Application No: LU/55/22/L

Site Address: The Flintstone Centre East Street Littlehampton BN17 6AW

Description of works: Listed building consent for the installation of 3000mm high welded mesh fencing and associated single leaf gate along a section of the northern boundary line and along the rear elevation, Ornamental fencing and associated gates to be installed, located adjacent to the existing southern side entrance to the building, as well as the installation of 3000mm high welded mesh fence encapsulating the existing boiler room to the rear of the building, demolition of existing side secondary entrance including existing ramped access and associated fittings. Repairs to the section of wall affected by the removal of the entrance.

Thank you for your internet representation made on 8th March 2022 which has been recorded as an objection with the comments as follows:

MESH DETAILS

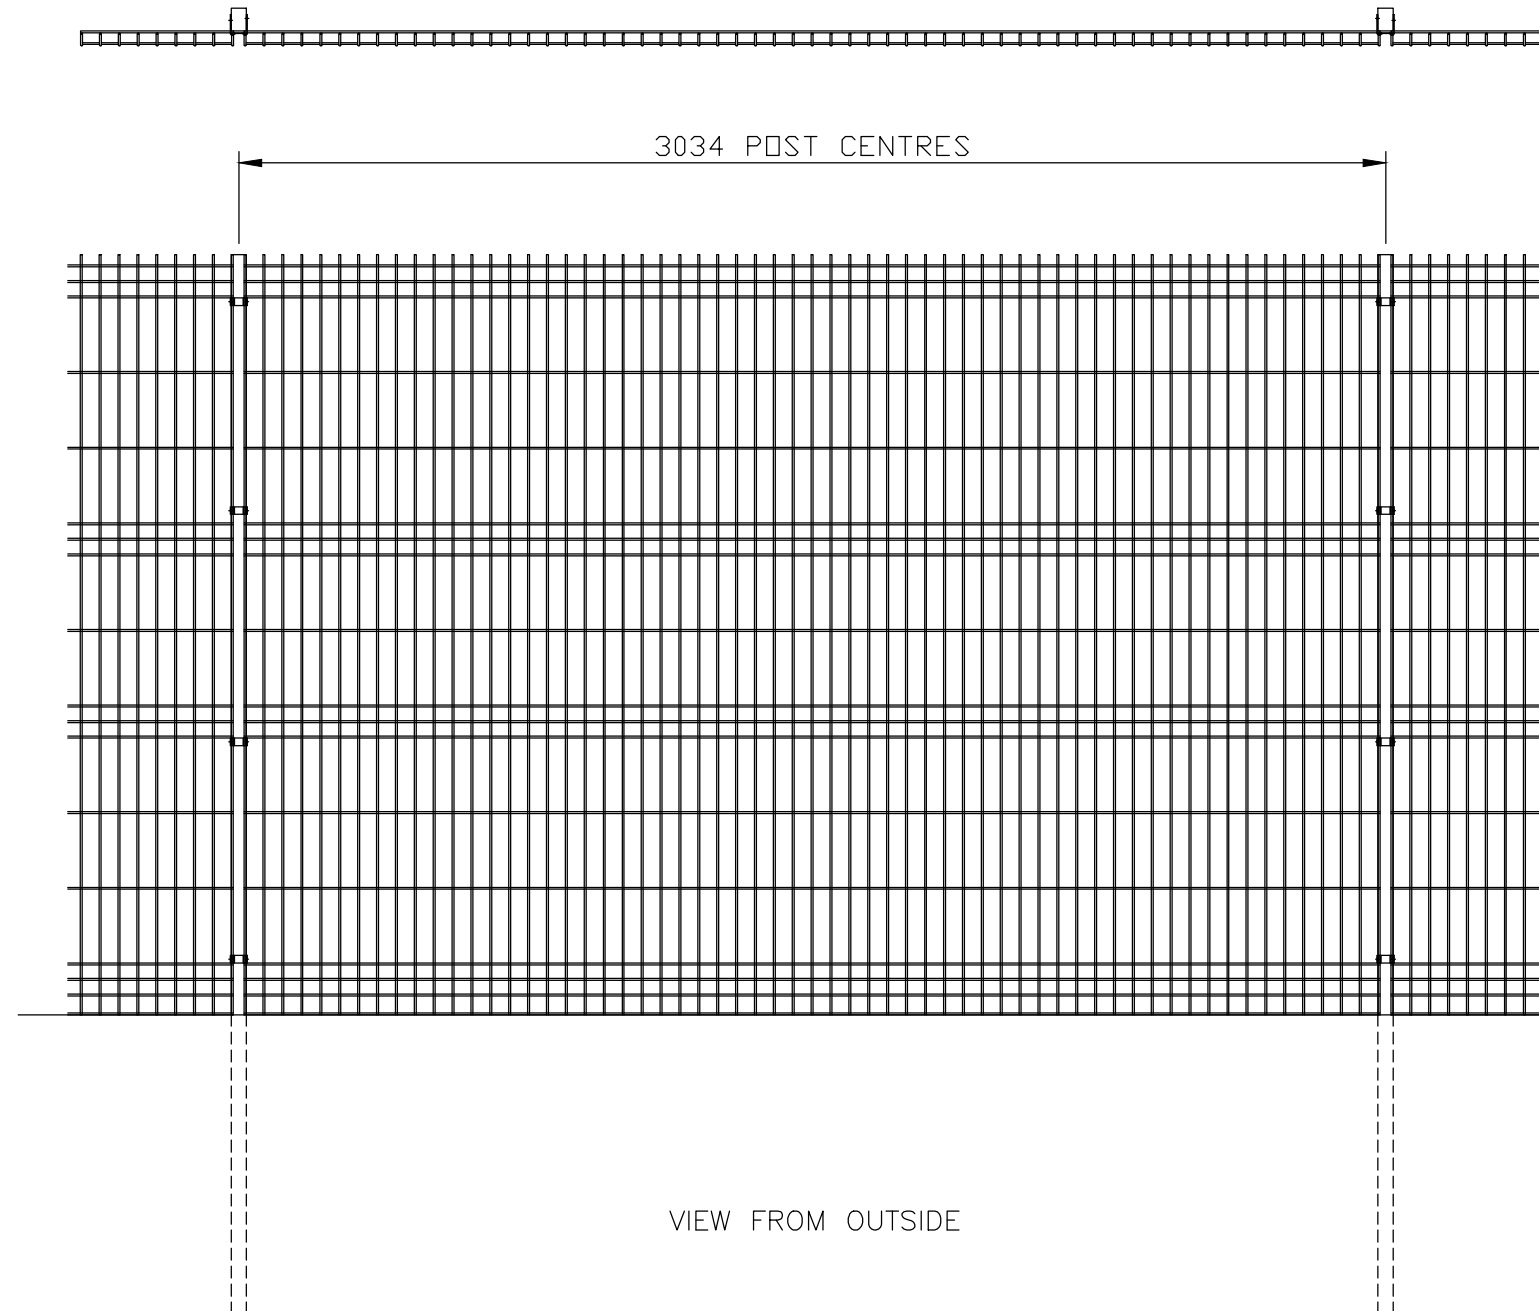
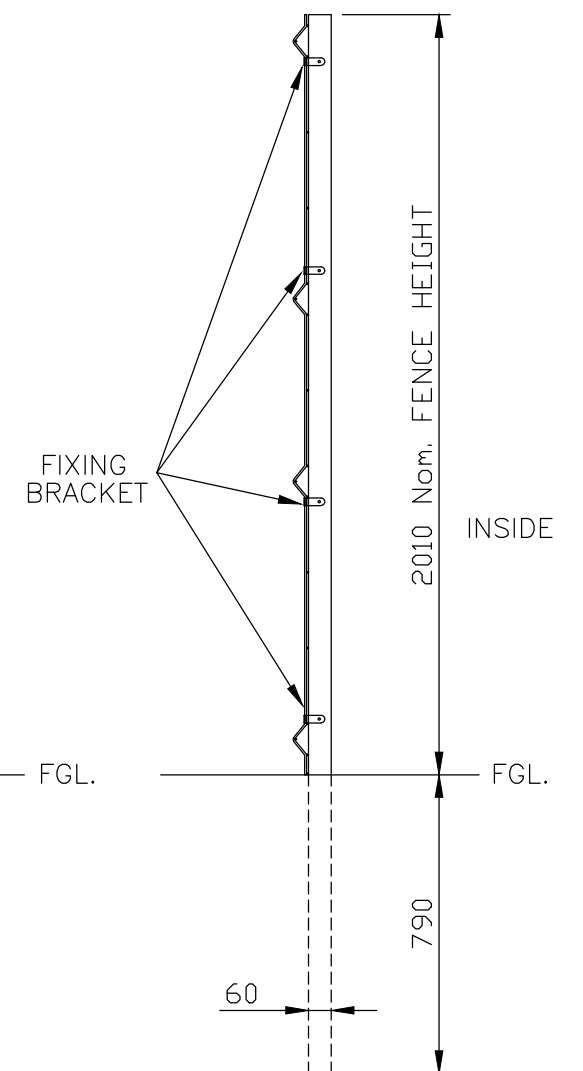
I note that the planning application mentions that the front elevation is to have a (2m) black ornamental style fencing (and gates) to reduce the visual impact of the fencing from a street view. The application also mentions that green welded mesh fencing is to be erected to the rear of the building as it is not visible from a street view. The planning also states that the sections of fencing to the rear is considered acceptable given their limited visibility. There appears to be little consideration of the Old Dairy Farm residents who will have this green (3m) high weld mesh fence as a permanent outlook to their properties rather than a passing view to the front of the Flintstone Centre. I also cannot see where the Heritage Statement has considered the close proximity of the Old Dairy Farm properties to the rear fence. It would be erected within approx. 10m of the front of a number of the properties at The Old Dairy Farm, protruding above the existing flint wall, and also alongside the whole garden wall of number 8. The rear fence in its current form will be ugly as well as inappropriate for a conservation area. The Old Dairy Farm development had to comply with a number of planning obligations due to it being in the conservation area including that of a Heritage style entrance gate and fence as well as Heritage style lamp posts (all adjacent to the Flintstone Centre rear flint wall). I also point out that the rear fence is to enclose the car park so not a playground or other area where pupils should gather due to the inherent health & safety risks of the car park. I have also personally been in regular contact with the planning agent firm during the revised planning process and had previously been informed by the Project Lead that the rear fence would be a black Heritage style metal fence so in keeping with the conservation area

and more acceptable for those Old Dairy Farm properties and residents that are in close proximity of it. I am now concerned to find out that this is not the case. I would however be supportive of a black Heritage style fence to the rear.
